4th June 2021
Our Ref: D1922
ADC Ref: AL/27/21/PL

RE: AL/27/21/PL - FORMER GRAIN STORES, SACK LANE, LIDSEY

Thank you for passing on the comments from ADC with regard to the Flood Risk Assessment and Drainage Strategy submitted for the above planning application. Please find my response below.

Chart 3: Summary of groundwater elevations

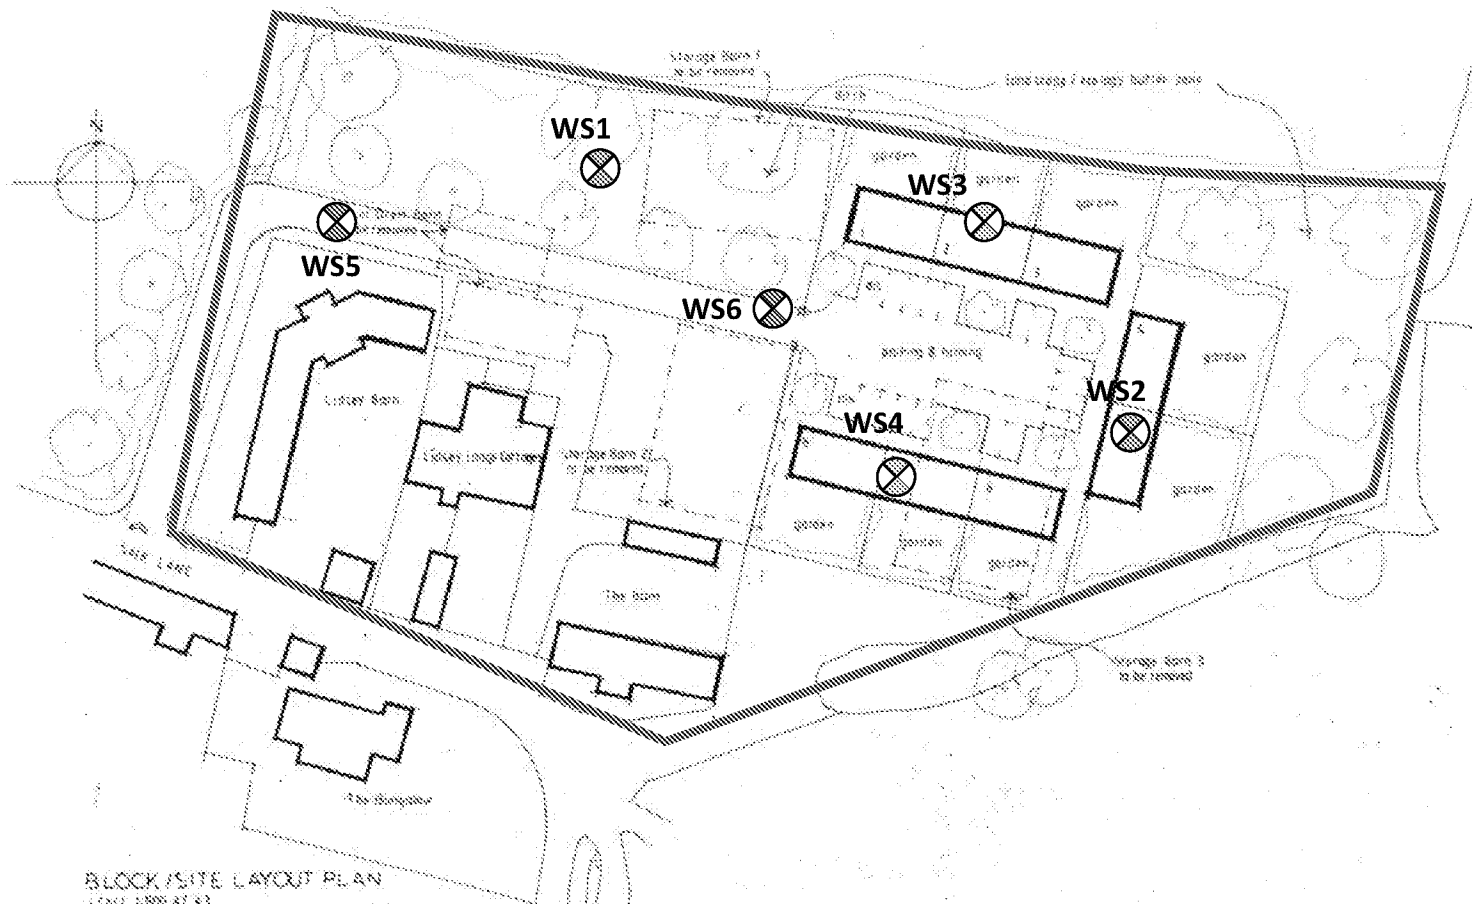
'The applicant has provided a Flood Risk Assessment [FRA] and conceptual Surface water Drainage Strategy for the site. Groundwater monitoring has been undertaken in the winter months up to 29/01/2021, we would expect to see the full winters results. Given that the report was dated February it is assumed that it was issued before the monitoring was completed, if a future application is made please include the results up to and including March 2021. On the basis of this being provided we will not be requesting any further groundwater monitoring if a future application is made.'

Please see attached in the revised report to support the new application the completed groundwater monitoring to 26th March 2021.

BRE Digest 365 - Soakage Test

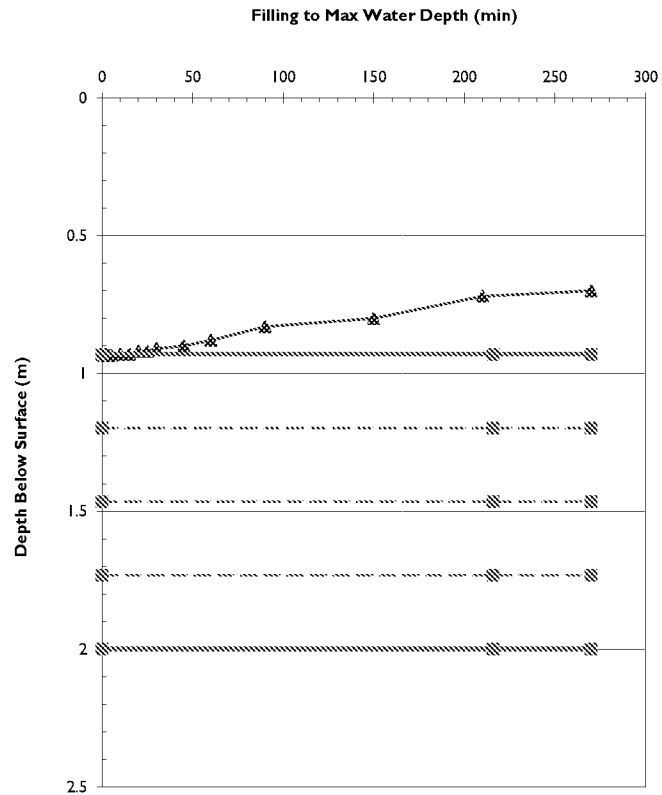
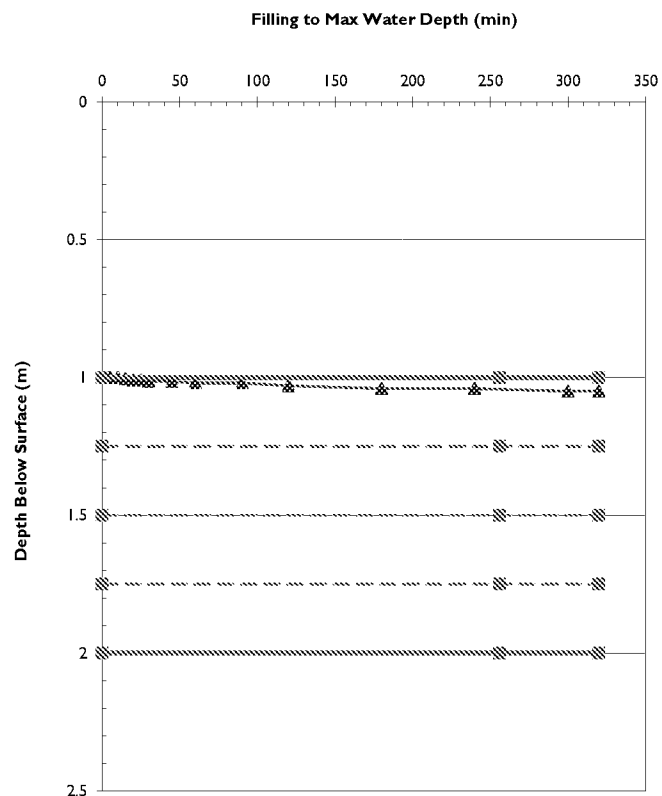
'Preliminary infiltration testing was undertaken in two boreholes on the site. This testing was not in accordance with DG365 as such will not be accepted as a justification for ruling out infiltration on the site. Whilst it is accepted that infiltration potential is likely to be limited/non-existent on the site, this needs to be evidenced with appropriate testing undertaken in winter months. The Leap ground investigation report supplied by the applicant recommends infiltration testing in accordance with DG365 (p29) and Paul Cann's e-mail of 9/2/2021 indicated the same (see appendices - point 6), so this requirement should be no surprise to the applicant.'

Upon review of the original application and the completed groundwater monitoring, we are agreeable that shallow infiltration testing, above the maximum groundwater level recorded of 0.75mbgl, is undertaken prior to detailed design to discharge the expected drainage conditions and provide the appropriate information for construction detail approval and Building Regulations.

We are also agreeable that should the further findings allow, the Designer should liaise with the LPA to utilise any infiltration potential for a infiltration-based or combined drainage solution, with a permeable geotextile subbase liner where appropriate.

We recommend that this further testing is undertaken between October 2021 to March 2022 to support the further development of this planning application and/or discharge planning conditions prior to commencement of construction. Should this not be viable, earlier testing could be undertaken as per the comments from Sarah Burrows.
